Your Ref: OWPC20364
Our Ref: WA/26/18/OUT 22-03-2018
Please ask for:
Mr J Baeza

Outline application with all matters reserved for 6 No detached houses with detached garages. This application is a Departure from the Development Plan.

Former Lanes End House Adjacent to West Walberton Lane & Arundel Lane Walberton

Thank you for your internet representation made on 1st November 2018 which has been recorded as '**an objection**' with the comments as follows:

Former Lanes End - Six Six bedroom detached Houses with Garages Proposed Layout Scale 1:100 @ A3 (c) PJ Developments LTD 2018		REVISIONS		01
		MM/DD/YY	REMARKS	
	1	--/--/--	...	A
	2	--/--/--	...	
	3	--/--/--	...	
	4	--/--/--	...	
	5	--/--/--	...	
West Walberton Lane Proposal

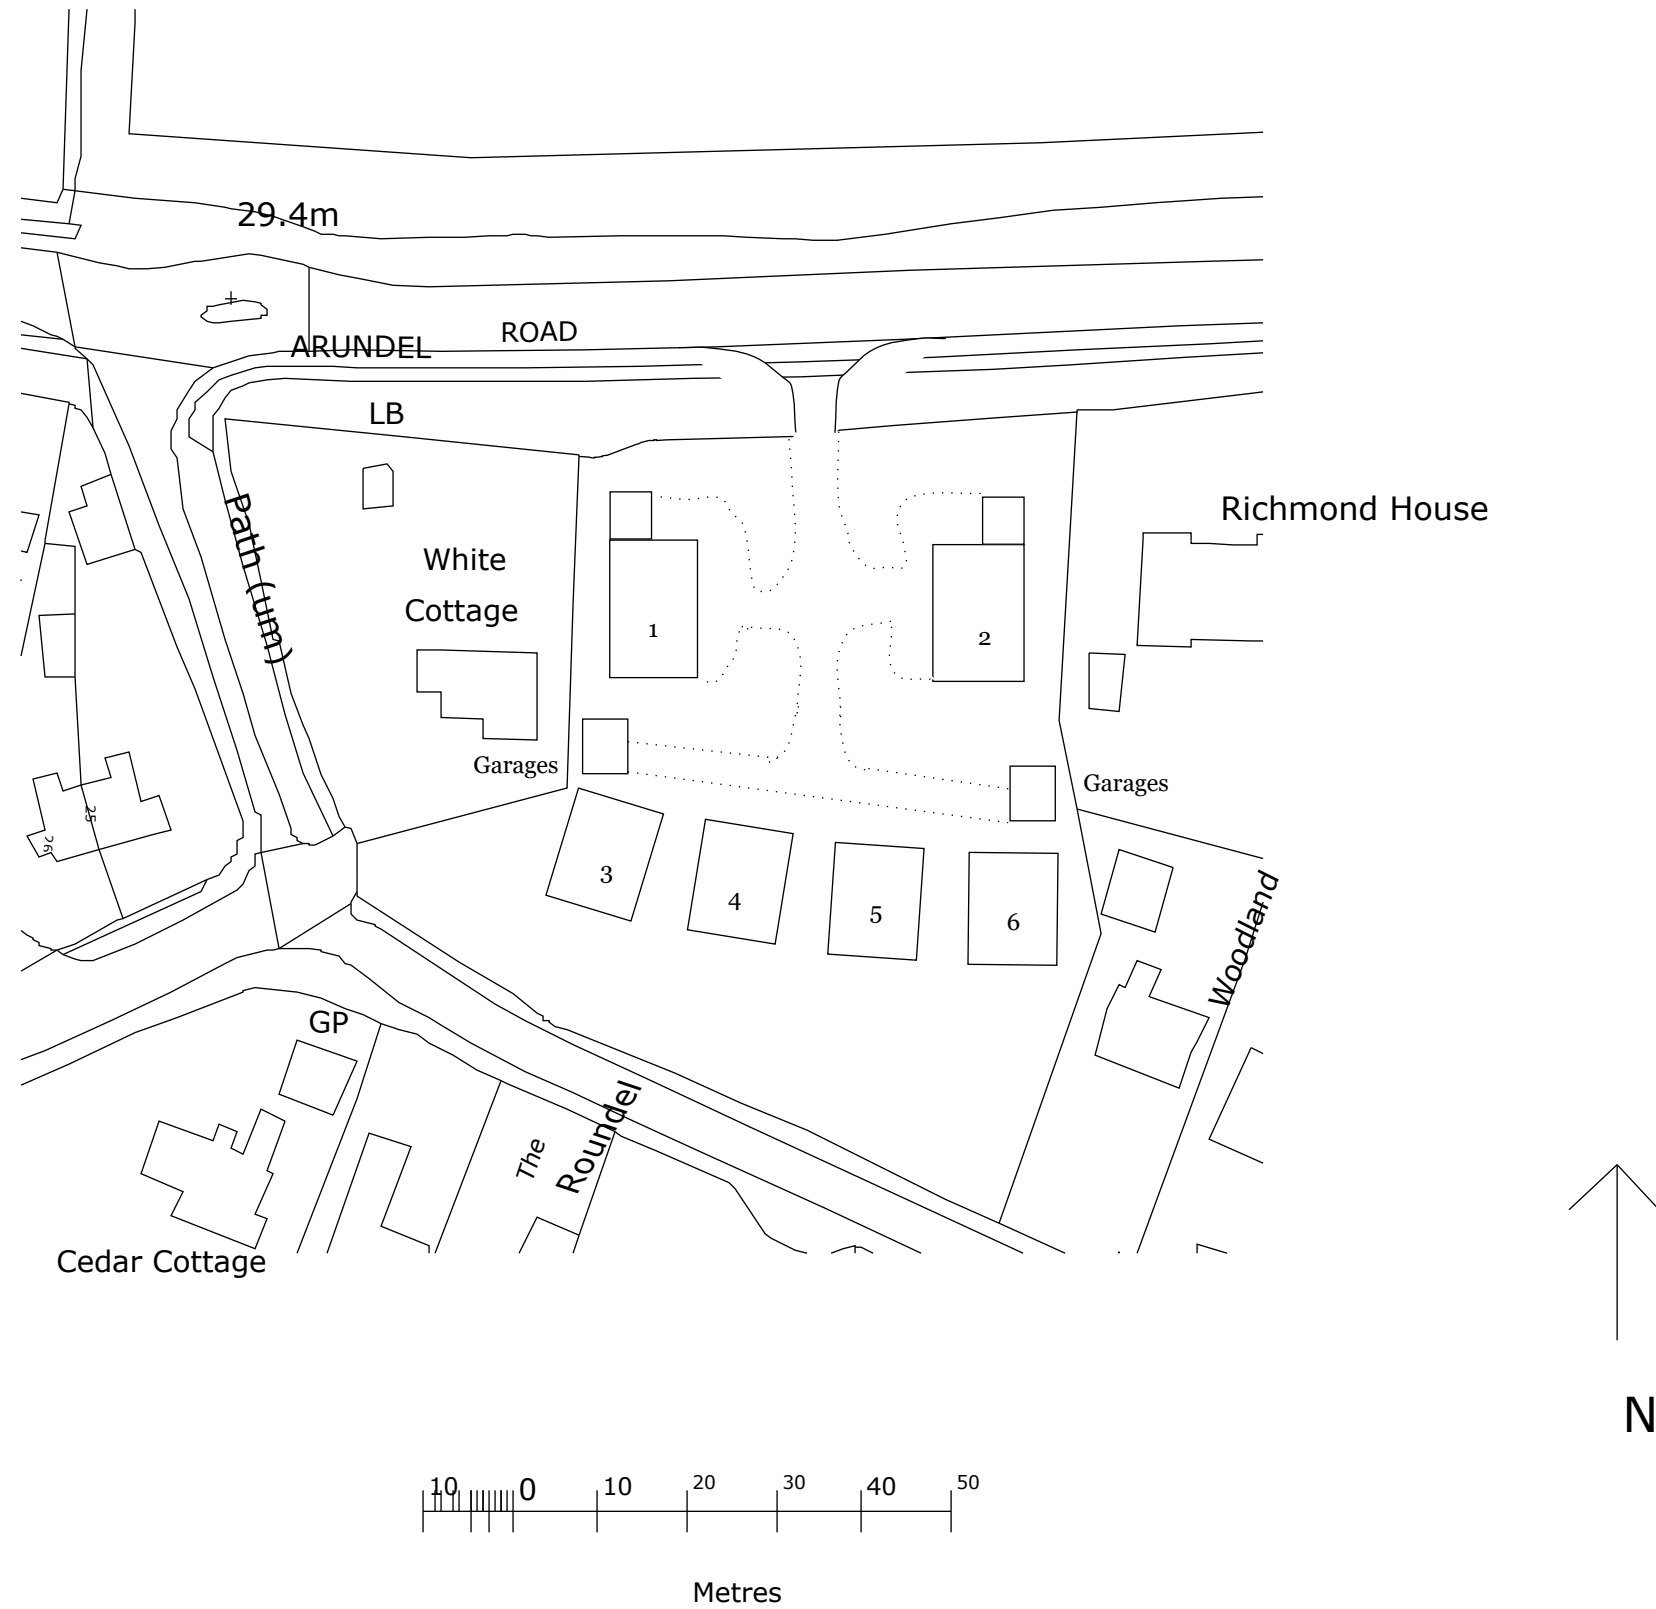
It would appear using the Applicants own figures the roof area of houses and garages is over 1000square metres almost 20% of the plot area and it is likely that with the need to have impermeable surfaces for emergency services to get to the properties this impermeable area could rise to in excess of 25%. This will have a considerable effect on the surface water run-off.

Additionally water from the A27 and the Old Arundel Road at present drained by roadside gullies may enter through the driveway unless a ramp and pipe is put in place.
